KIRKLEES METROPOLITAN COUNCIL INVESTMENT & REGENERATION SERVICE

Reference No:	2026/62/91492/W
Site Address:	71a, Woodside Road, Beaumont Park, Huddersfield, HD4 5JF
Description:	Demolition of existing garage and erection of replacement garage with two storey side extension
Recommending Officer:	Joshua Merriman

Officer Report – 2026/91492

SOUTH ELEVATION

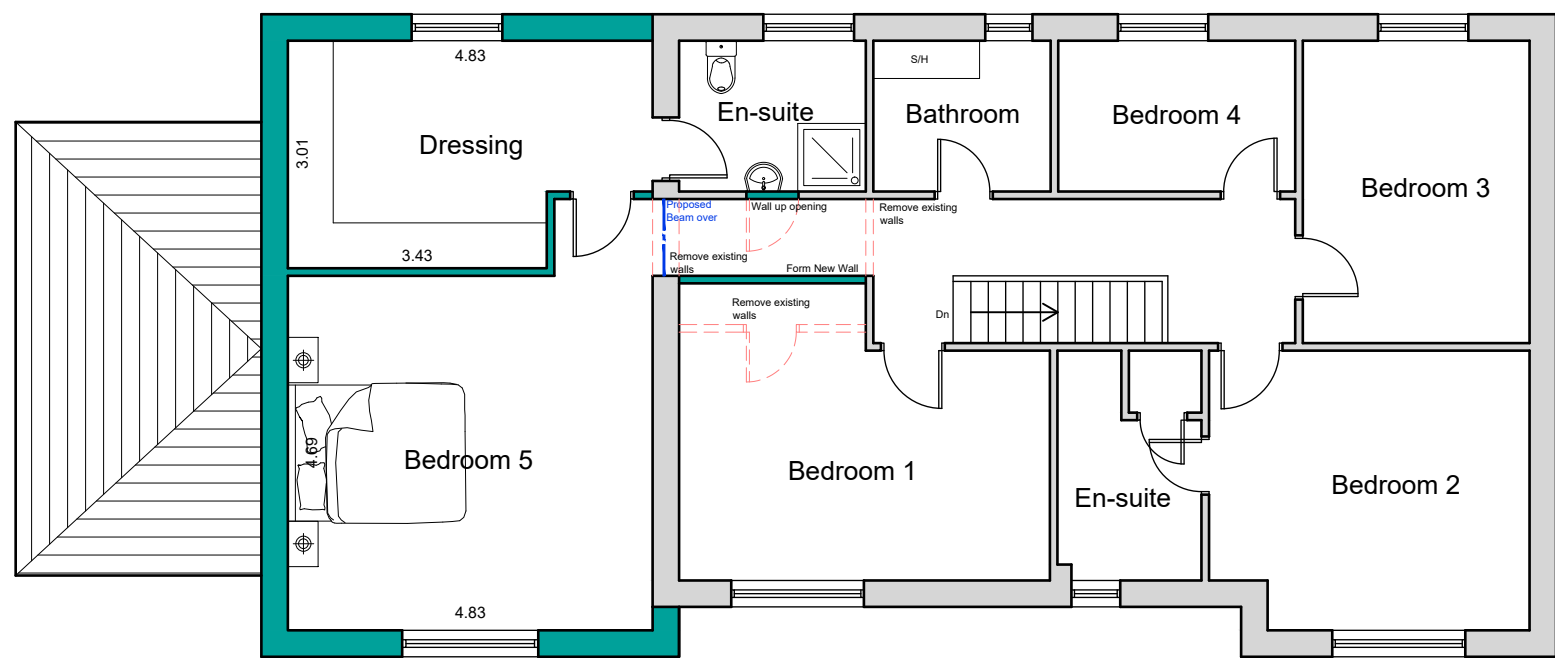
The two-storey side extension, although not set back 500mm from the front elevation of the property, will appear visually sympathetic in keeping with the design of the dwelling so as not to look out of character. The extension will also have a roof design which follows that of the host property, and use sympathetic materials including stone, grey slate roof tiles, and uPVC windows and doors.

The proposal ensures that both the North and South elevations of the development appear as frontages to address both Woodside Road and Butternab Road given the properties corner plot location.

As the closest neighbouring property is 16m to the South and any new windows facing South are not projecting further forward than those in the dwelling, it is considered that there will be no significant impact upon overlooking or privacy. All neighbouring properties in other directions are a minimum of 31m away.

FIRST FLOOR PLAN

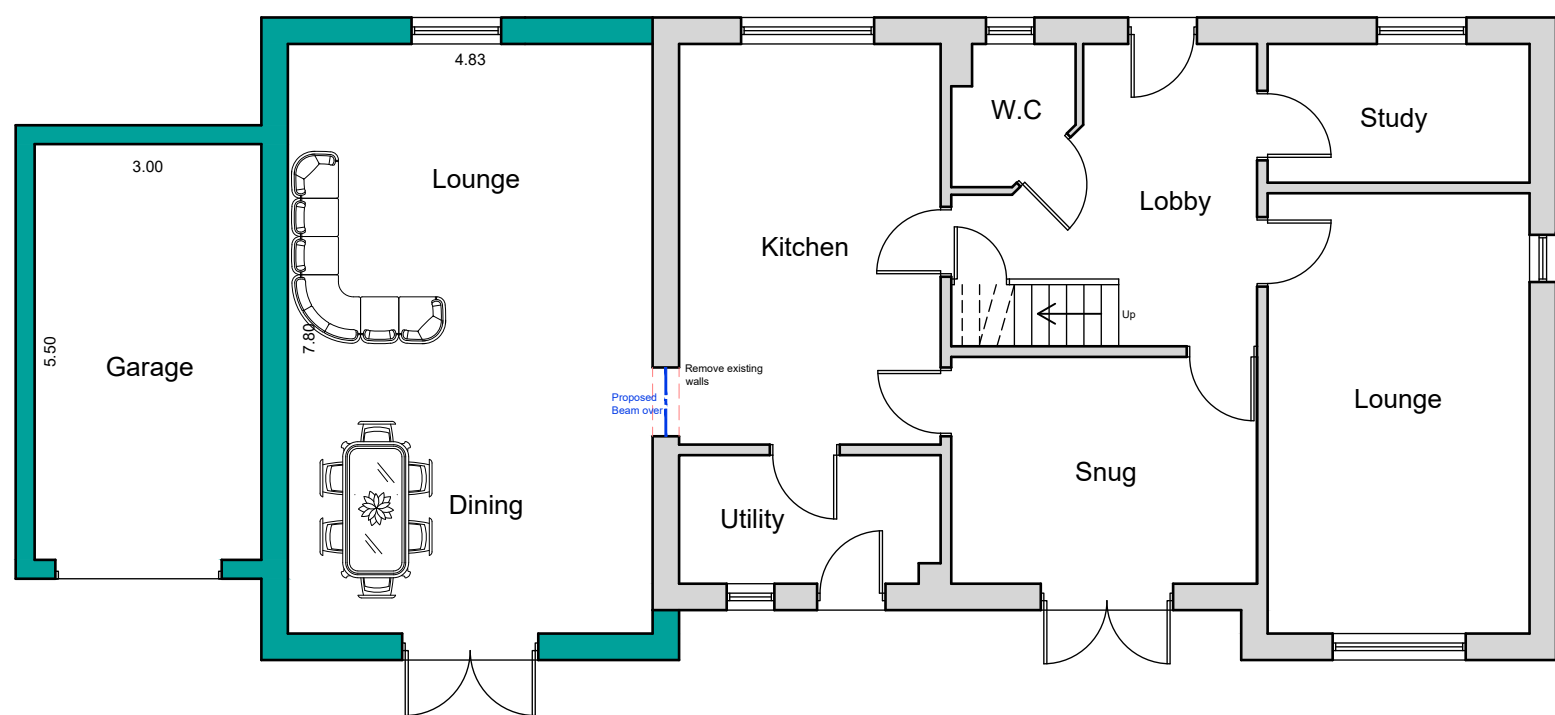
The two-storey side extension does not take up all the space to the side of the property. Given that there is no neighbouring property to this side of the dwelling, it is considered that there would be no adverse impacts on residential amenities as a result.

The proposal will increase the number of bedrooms in the property from four to five, however, the scale of the hard-standing parking area on site will not be impacted, therefore, the current parking provision at the property is acceptable to remain as the requirement for off-street parking spaces will not increase because of the proposal. It is noted that the garage will be reduced in scale, and will therefore not be large enough in scale to accommodate an off-street parking space, however, the hard-standing area to the front of the dwelling is considered to remain adequate. Furthermore, the proposal is set well back from the closest highway and is not considered to have any significant impact upon highway safety.

BLOCK PLAN AT 1:500

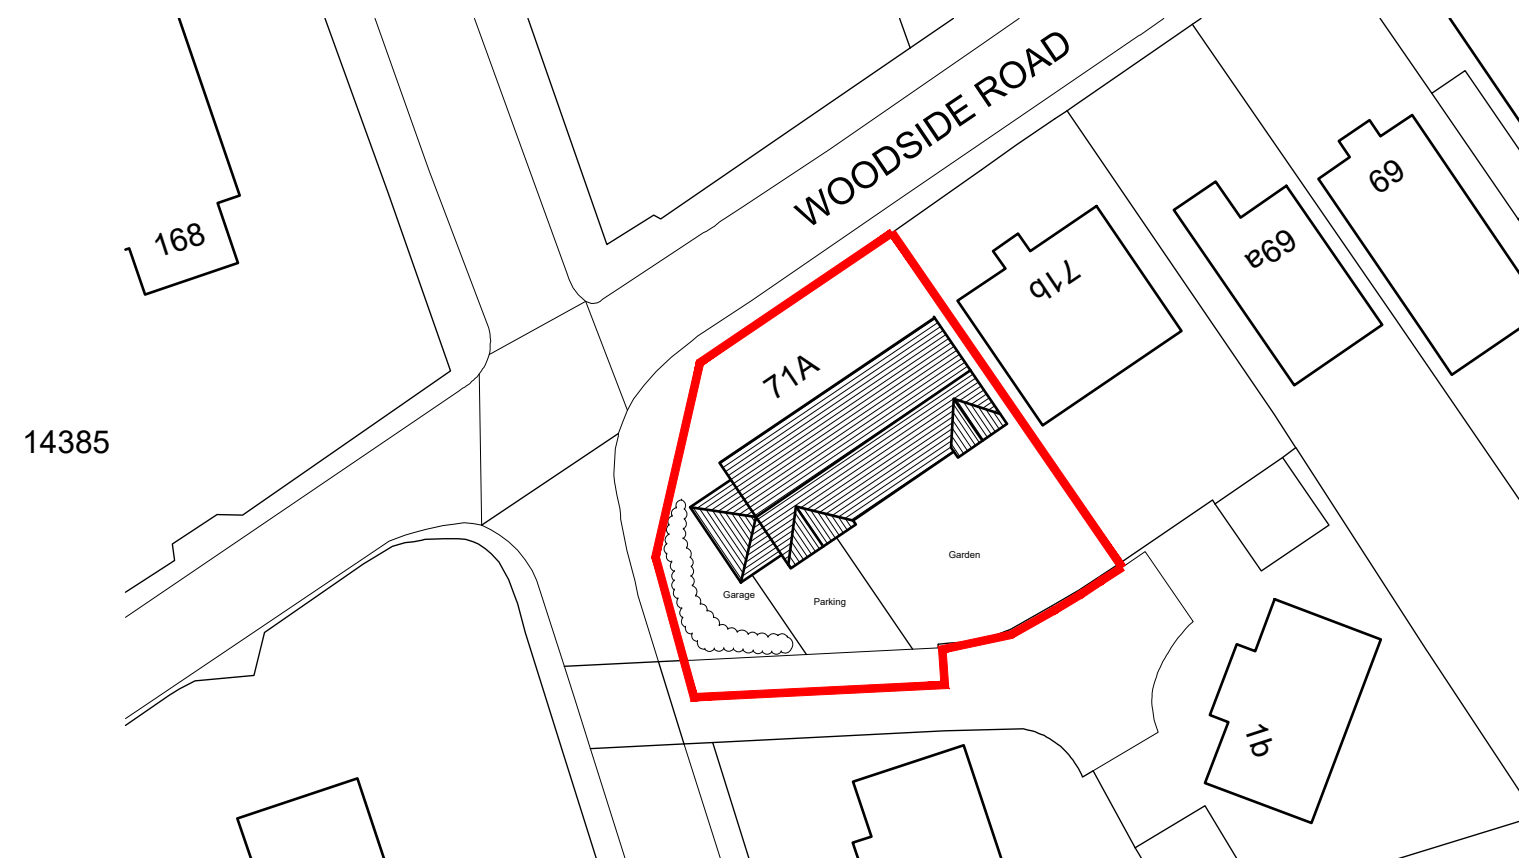
The dwelling will retain amenity space to the front, side, and rear which amounts to at least 50% of the total existing amenity space.
